HIGHWAY AND LEAD LOCAL FLOOD AUTHORITY RESPONSE TO CONSULTATION ON THE FOLLOWING DEVELOPMENT PROPOSAL

Application number: H09-1278-25

Proposal: Proposed erection of 2 bungalows

Location: Land east of Forest Way, Holbeach, Spalding

DRAWING NUMBER : LDC4657 - 10

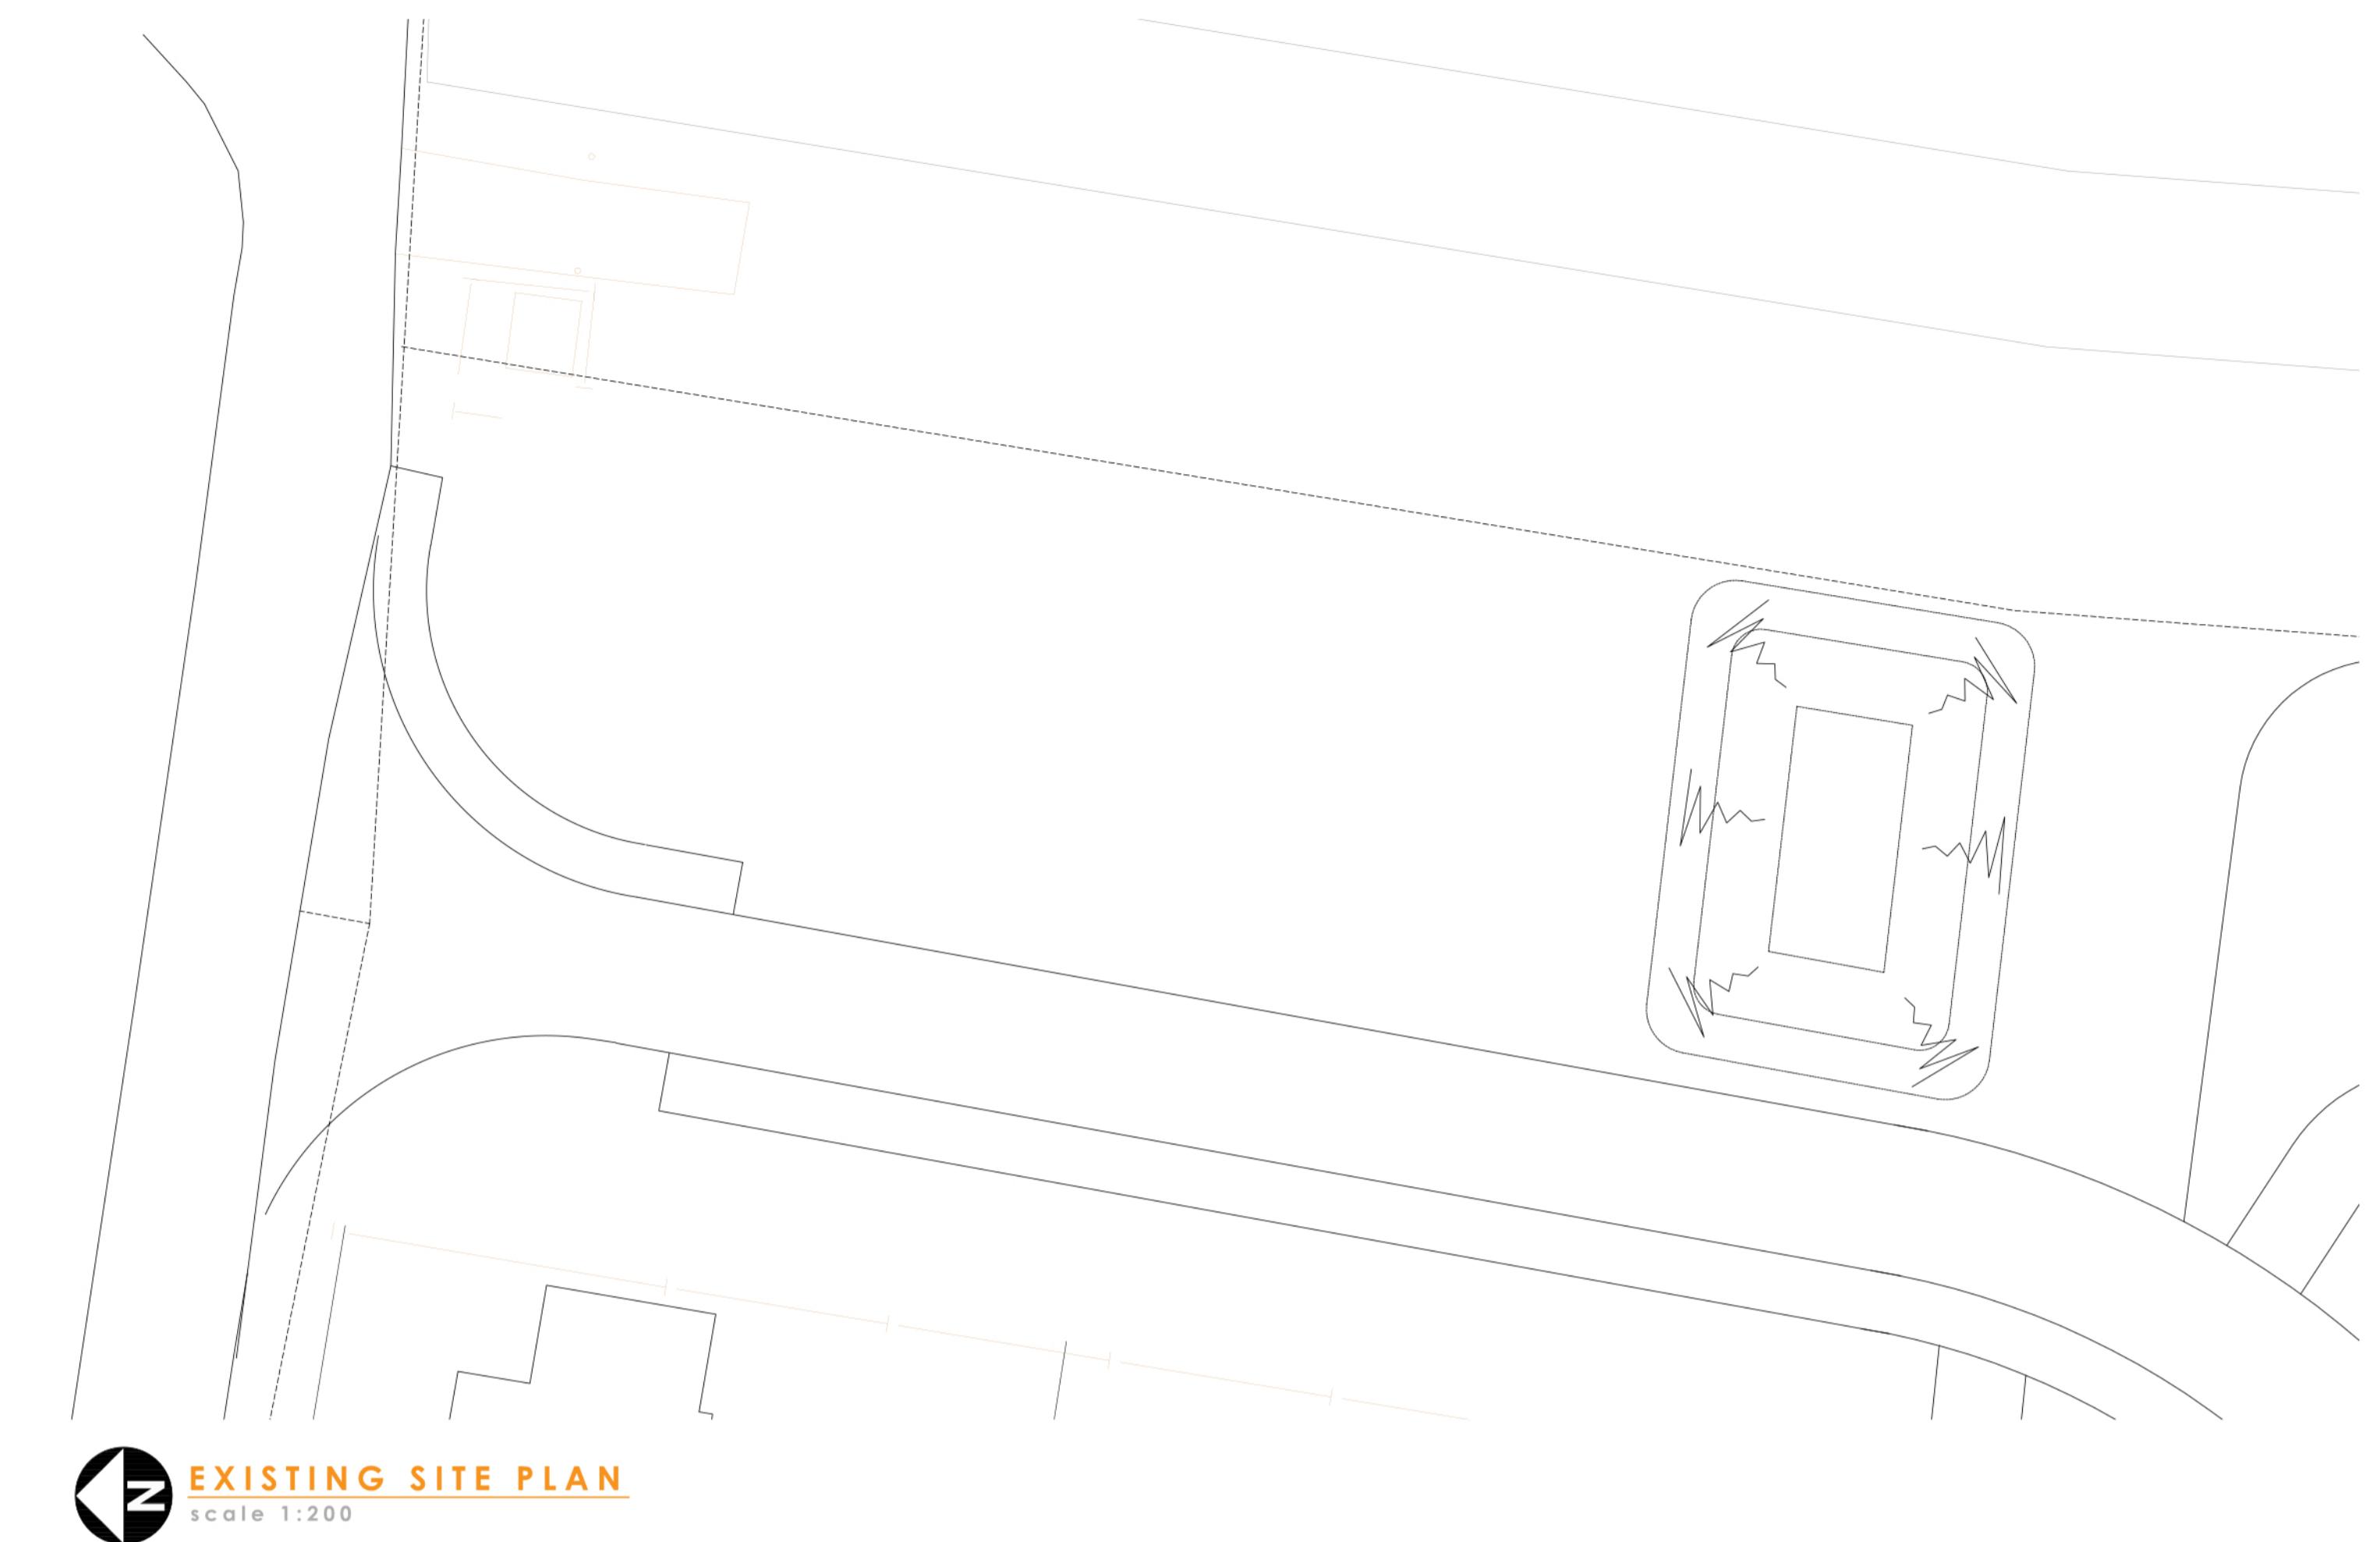
Proposed erection of 2 bungalows. Visibility from Forest Way on to Wignal's Gate is good and the speed limit is 30mph. I had no safety concerns exiting Forest Way onto Wignal's Gate. The proposed bungalows are set well back from the junction so they will not have an impact on the visibility at the junction. There is a connecting footway from Wignal's gate into the site that crosses over adjacent to the first plot. This will continue to work as it does and there will be no safety implications here with the proposal. The site plan demonstrates sufficient off-street parking for the size of the dwellings in accordance with the South East Lincolnshire Local Plan and guidance in the Lincolnshire County Council Design Approach document. Vehicles leaving the parking spaces will have clear visibility of oncoming traffic, the open space at the junction detailed on the site plan will remain and any boundary treatment here should be kept at a height no higher than 0.6m to ensure the visibility will not be impaired. It will not create pedestrian and vehicular conflict – vehicles will emerge with care leaving the proposed bungalows as those would also do entering Forest Way from Wignal's Gate. Forest Way has a long, straight entrance road, and road users have clear visibility of oncoming vehicles. Should a vehicle be parked up, on the highway fronting the plots, road users are able to pull over and wait for any oncoming vehicles to pass. This would not create a safety implication as the plots are well away from the junction and the users of the public highway have clear visibility. The proposal will not have an adverse impact on highway safety.

Any boundary treatments from the front of the buildings to the public highway shall not exceed 0.6 metres high.

Prior to first occupation on site further details relating to the vehicular accesses to the public highway, including materials, specification of works and construction method shall be submitted to the Local Planning Authority for approval. The approved details shall be implemented on site before the development is first occupied and thereafter retained at all times.
